SUBJECT: **SFD2505-0001**  
**SINGLE FAMILY DWELLING**

Here are the results of all Inspections located at **55 FERN RDG:**

MONOLITHIC SLAB FOUNDATION PLAN
ELEVATION 3

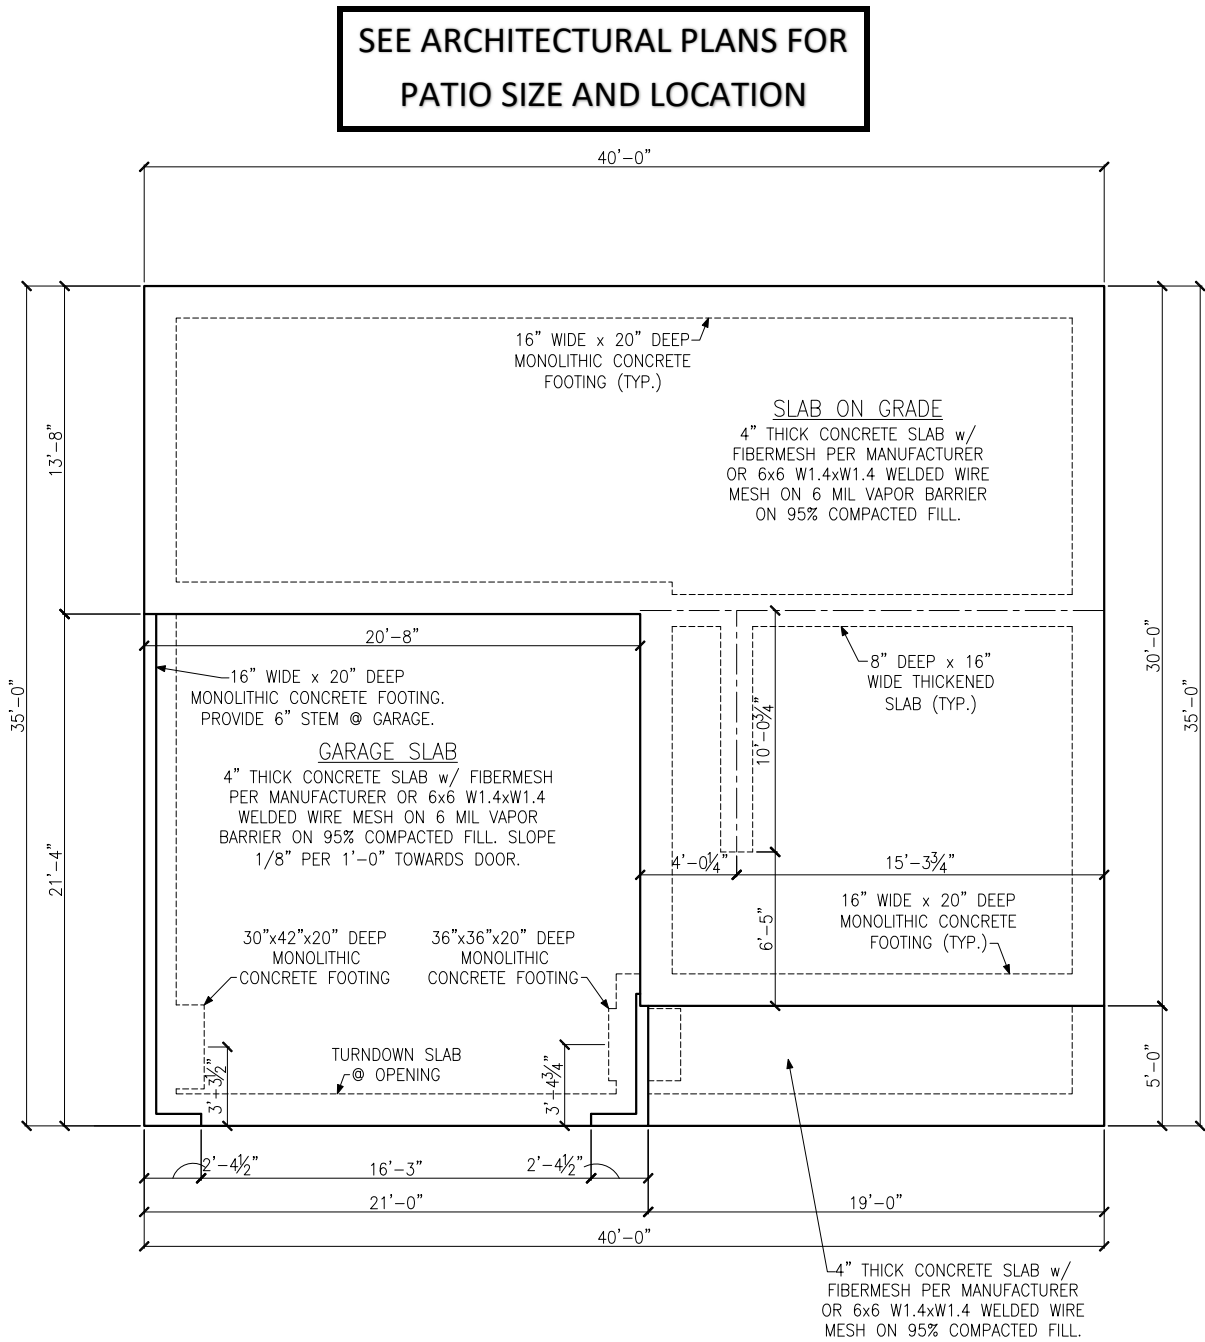
Inspection Type: MONO SLAB  
Scheduled Date/Time: 7/22/2025  
Completed Date/Time: 7/22/2025  
Inspector: Ricardo D Honrada  
Result: DISAPPROVED  
Remarks: eTRAKiT Inspection Request  
Notes: 7/16/2025 5:09 PM Glenwood Homes

Wall footings in garage 20 inches deep as per plan
